Recommendation Report for Planning Permission for Works or Extension to a Dwelling

REF NO: EP/49/26/HH

LOCATION: Tuts Cottage
Manor Close
East Preston
BN16 1JF

PROPOSAL: Single storey extension and alterations to existing property. Including porch extension, construction of new chimney, alterations to fenestration and replacement roof tiles. This application may affect the setting of a Listed building

Drawing Name
Ground Floor Plan -
Proposed

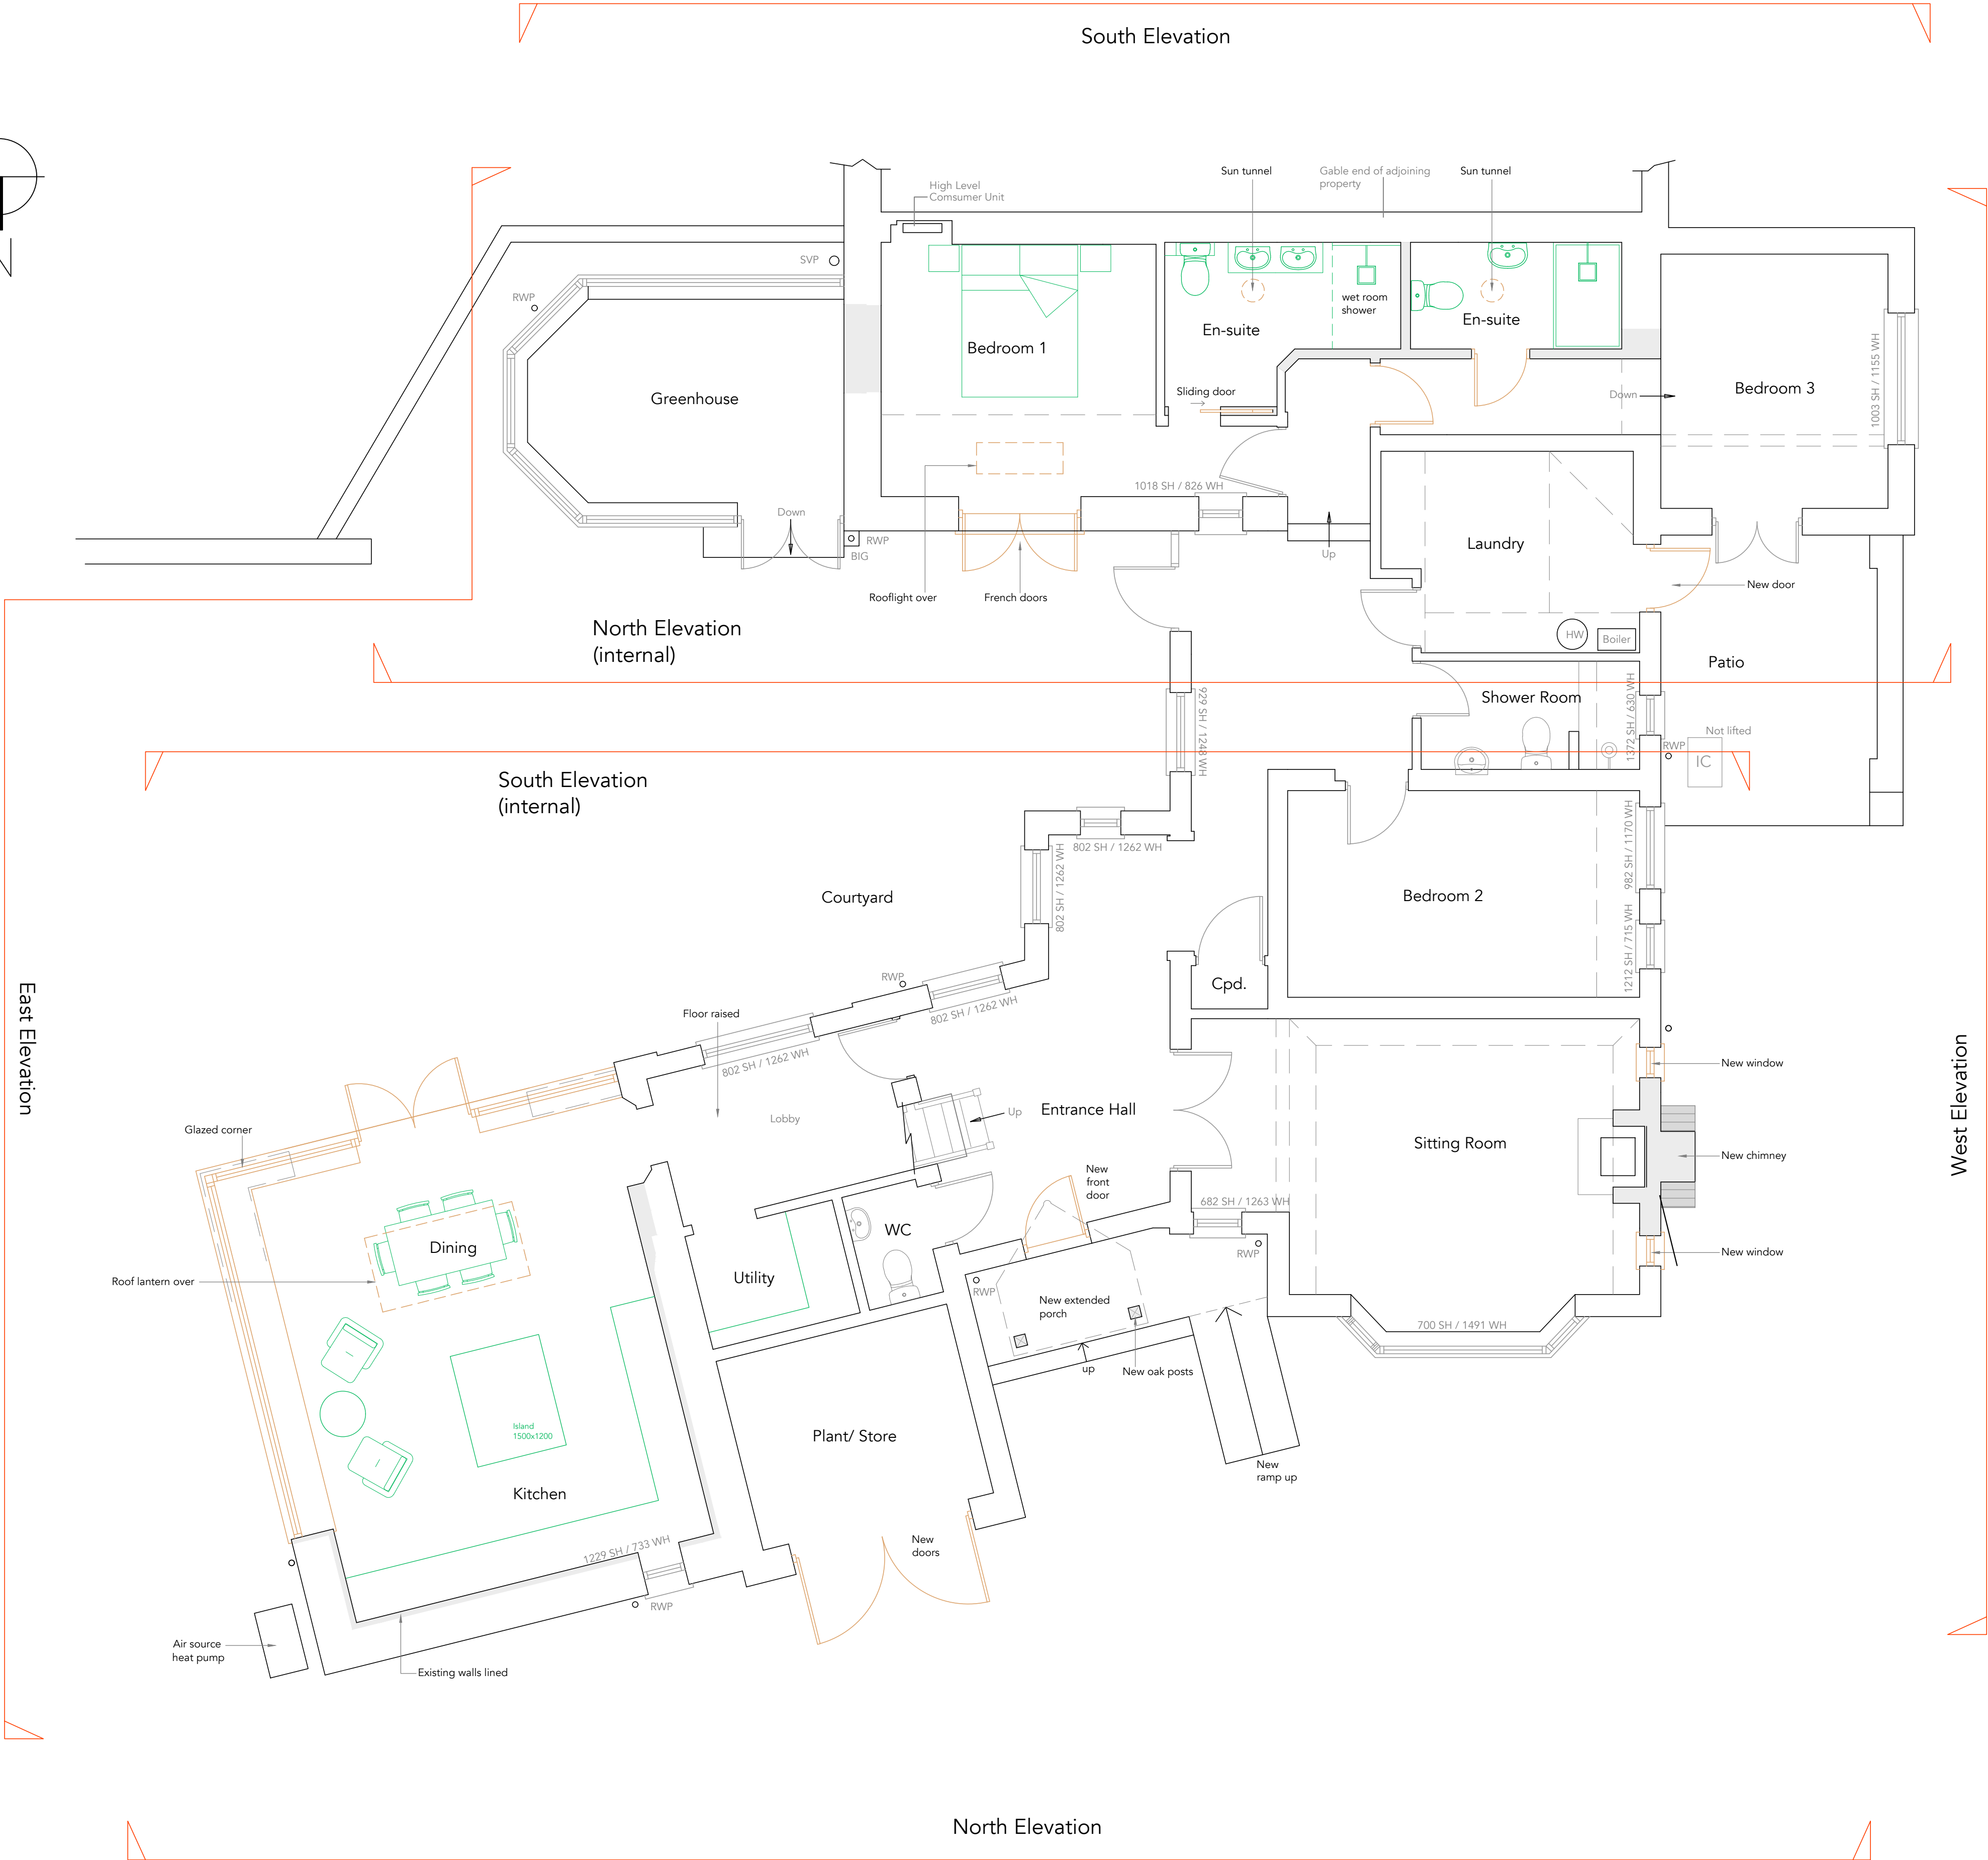
The proposed rear extension would infill the existing area between the bedroom and rear porch to create a new kitchen. The extension would measure approximately 5.7m in width and 6.7m in depth and would be finished with a crown roof form incorporating a flat roof section with a maximum height of approximately 4m. This represents a reduction of approximately 0.9m in ridge height when compared with the existing hipped roof. The extension would be constructed using materials that match the existing dwelling, including brickwork to the new walls, while the existing northern elevation would retain its characteristic mix of brick and flint. New plain clay roof tiles are proposed, matching the appearance of the existing roof covering.

The rear extension would incorporate extensive glazing, with the eastern and southern elevations largely glazed through traditional style sash windows that reflect the appearance of the existing fenestration. A lantern rooflight is proposed within the flat roof section, together with patio doors providing access to the private courtyard.

Additional fenestration alterations are proposed throughout the dwelling. These include the installation of a new garage door incorporating upper glazing, a new French door replacing an existing window on the internal northern elevation, a patio door replacing an existing window on the western elevation, together

with a rooflight and two sun tunnels within the southern roof slope. These changes are required to facilitate the proposed internal reconfiguration and would be appropriate in design terms. As such, the proposed alterations to fenestration would be in accordance with Arun Local Plan policy D DM4.

Drawing Name
Roof Plan -
Proposed

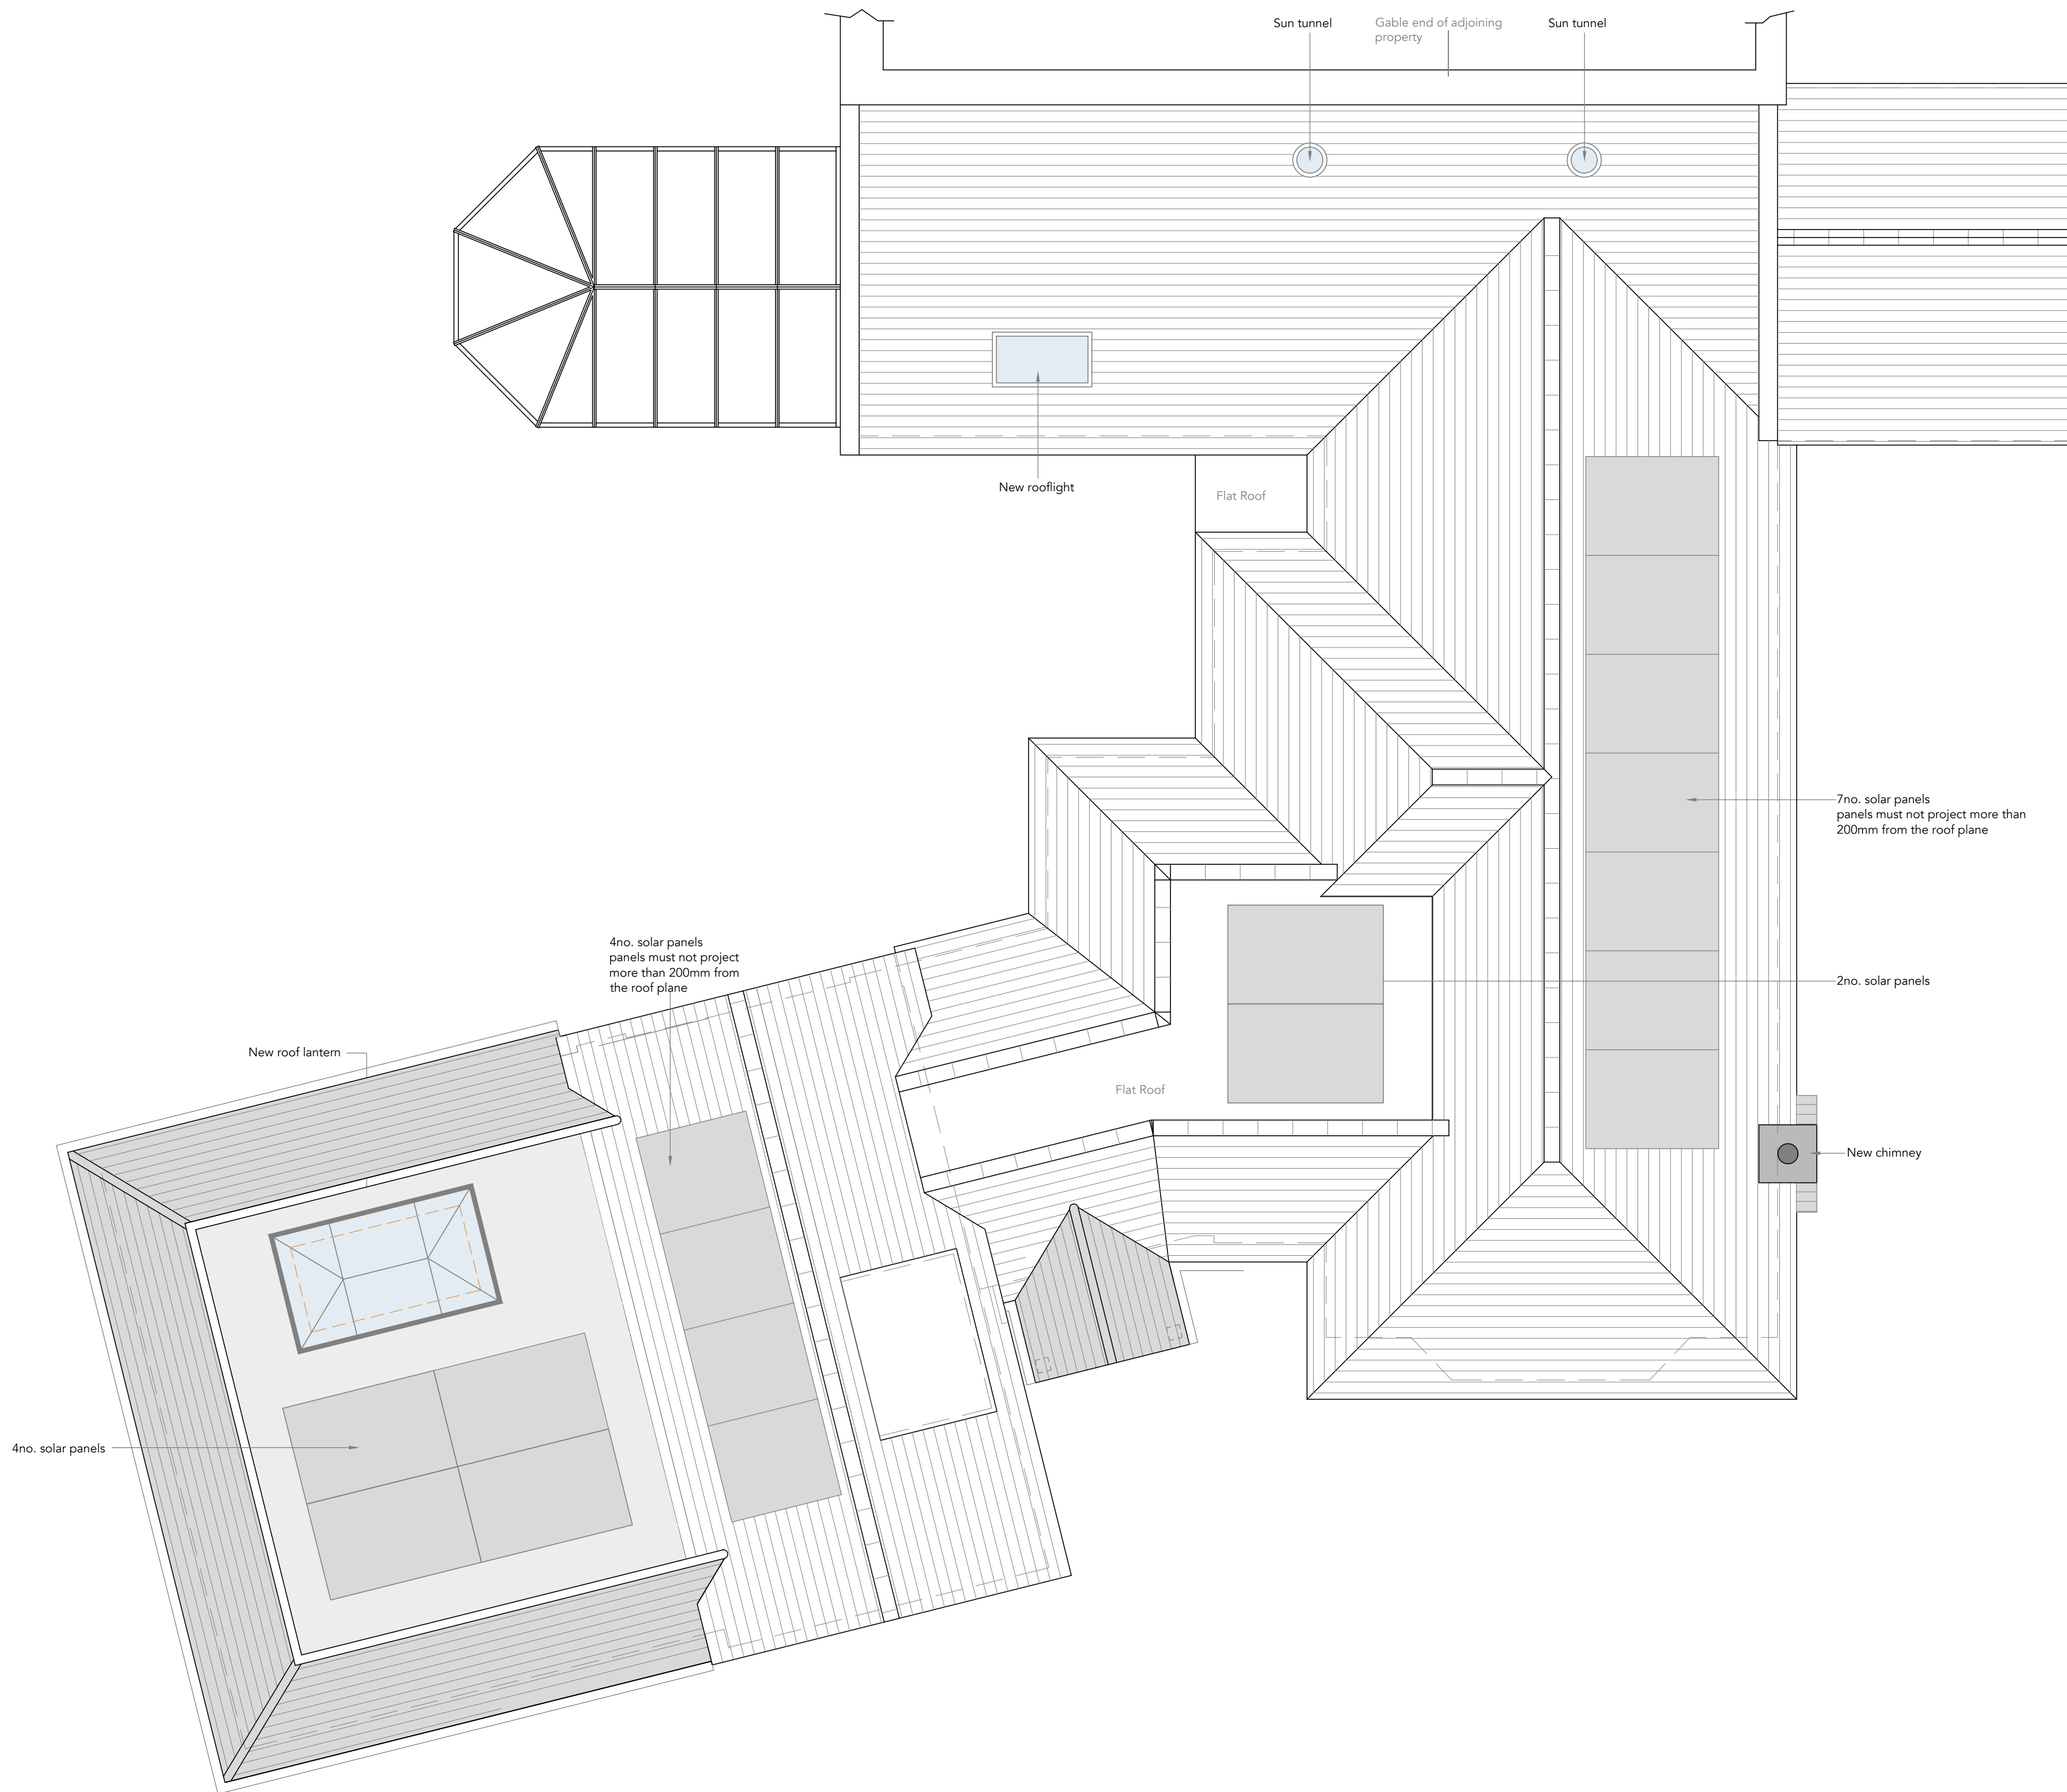
The majority of the proposed works are acceptable from a heritage perspective. Whilst I have some reservations regarding the extent of the proposed solar panels and the associated changes to the roof, I understand that these works may be permitted development. If this is the case, they would fall outside the scope of matters that can be controlled through this application. Overall, taken as a whole, I consider that the proposal would have a neutral impact upon the significance of Midholm.

The proposal also includes the installation of 17 solar panels across various roof slopes, together with replacement roof tiles matching the existing. Whilst the solar panels would be visible from the street and would introduce a modern element that would have some effect on the setting of the adjoining listed building, they would be acceptable in principle. Significant weight is given to the sustainability benefits of renewable energy generation, and it is noted that similar works could be undertaken under permitted development. As such, the proposed solar panels are acceptable with regards to visual amenity, in accordance with Arun Local Plan policy D DM4.

Drawing Name
Elevations -
Proposed

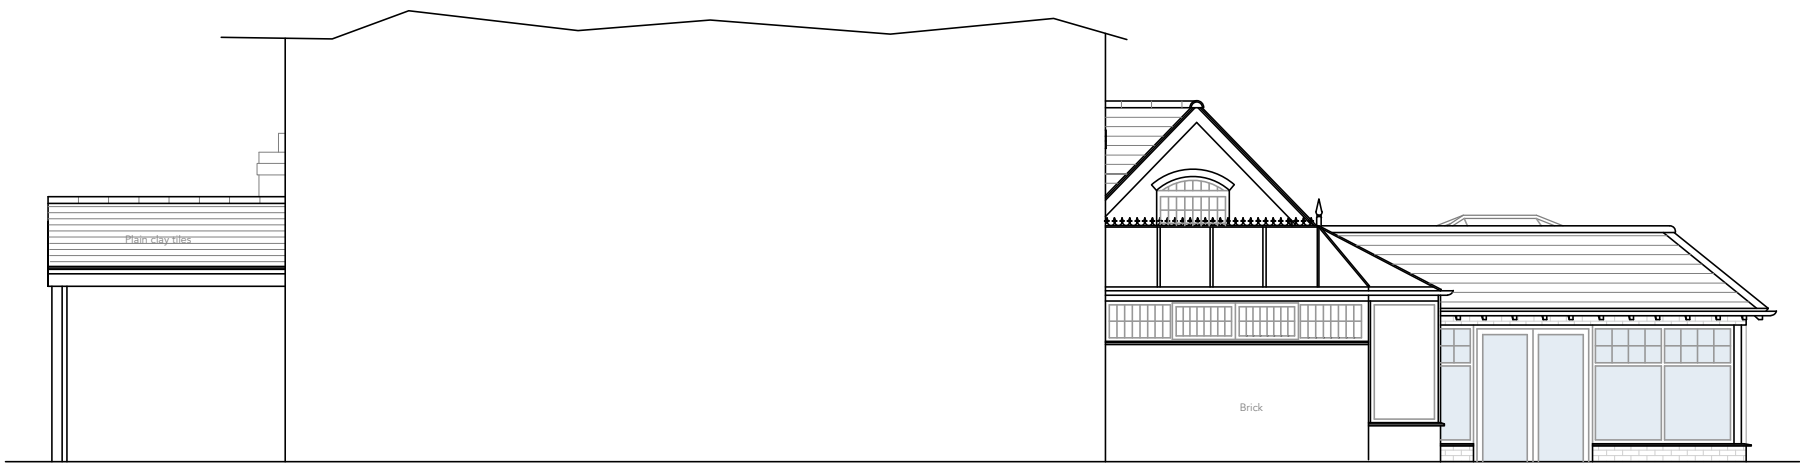
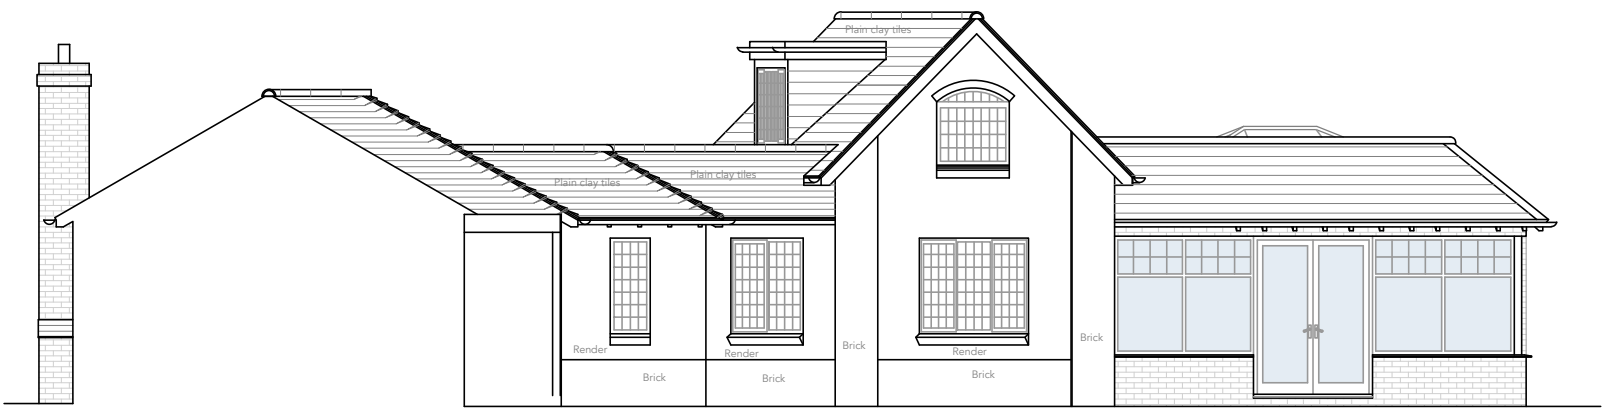
To the front elevation, the existing porch would be extended to provide improved access arrangements, including the introduction of a ramp. The porch would have a pitched roof form with a maximum height of approximately 3m, supported by two oak posts, and would measure approximately 7.6m in width and 2.46m in depth. The proposal includes steps to the entrance door and a ramp approximately 4m in length and 2m in width. The provision of step-free access would represent a positive aspect of the scheme, improving accessibility for those with mobility impairments.

Whilst the proposed porch would exceed the ADG's recommended maximum depth of 1.5m for front extensions, it would not project beyond the established building line. The traditional roof form, open design, use of appropriate materials and the functional requirement to accommodate the access ramp would make this departure from ADG acceptable. Furthermore, the porch would be acceptable in visual terms and integrate well with the existing dwelling.

A new brick chimney stack is proposed on the western elevation, positioned between two sash windows. The chimney would have a maximum height of approximately 5.2m, which is comparable to the existing ridge height of approximately 5.5m. Given its proportions, traditional form and materials, the chimney would appear as a complementary architectural feature and would not appear incongruous within its setting or wider street scene, in accordance with Arun Local Plan (ALP) policy D DM1.

The proposed chimney stack would have an overall height lower than the existing ridge height and would therefore not result in any overbearing impact. The new sash windows proposed adjacent to the chimney within the western elevation would be positioned approximately 3.3m from the boundary and would be further separated from neighbouring properties by the public highway. As a result, the windows would not give rise to overlooking or loss of privacy.
